Covering Letter

Application for Approval of Details Reserved by a Condition

Planning Application: 23/01154/APP

Approval of Details Reserved by Condition: 23/B1154/DIS

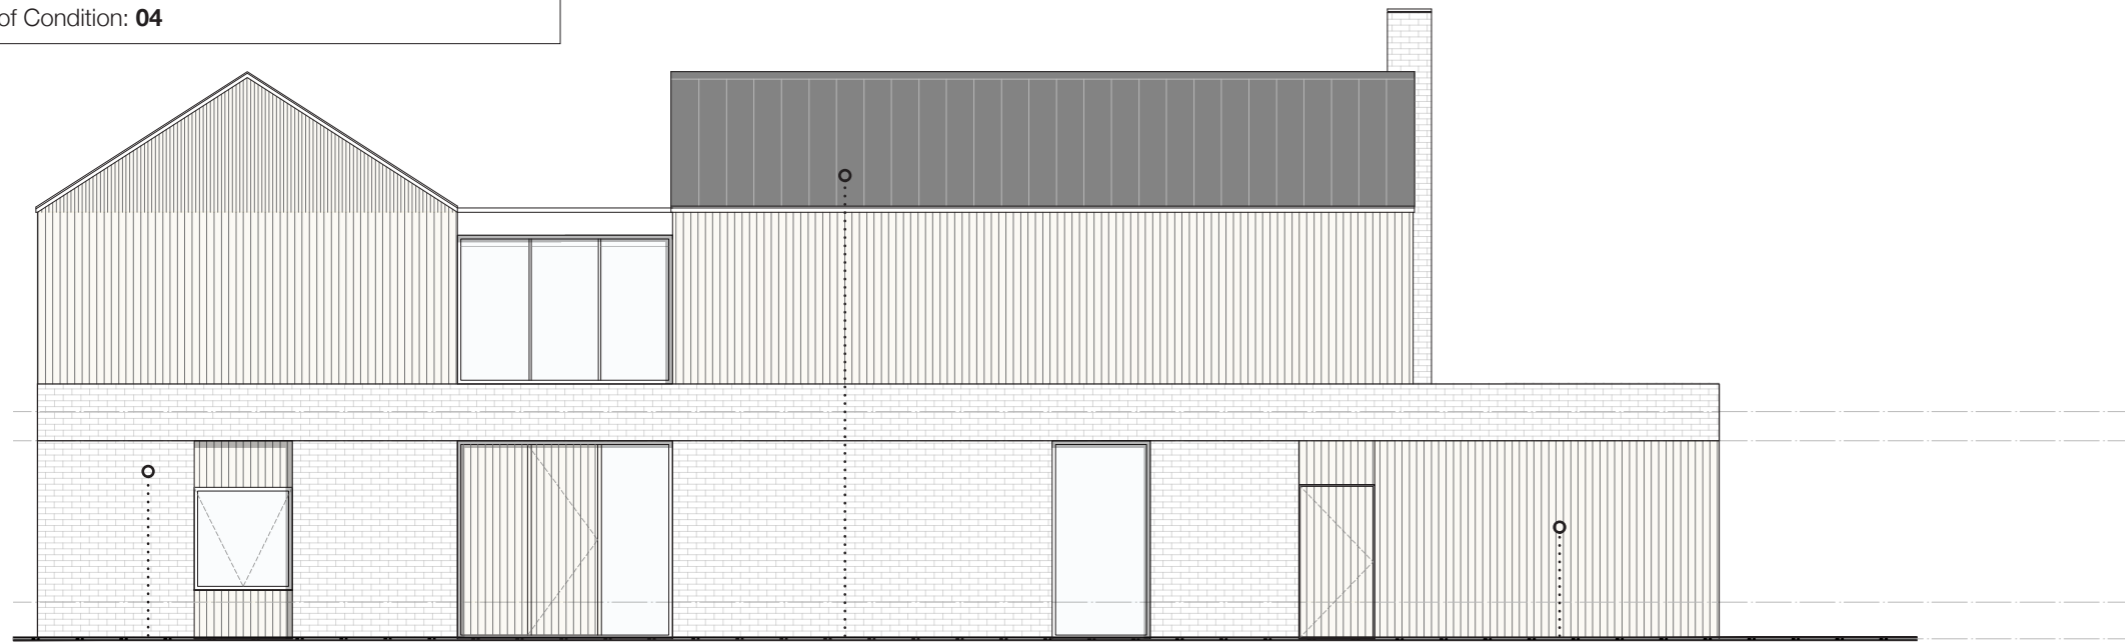
Following the discharge of conditions 04 and 12 under application 23/B1154/DIS, we propose a change in the roofing material (condition 04) and the specification of the solar panels (condition 12).

The proposed change is to an integrated solution whereby the standing seam panels and solar panels are as one. The Roofit panels cover the entire roof plane providing a seamless approach to the design and increase the system potential by 50% to 14.72 kw.
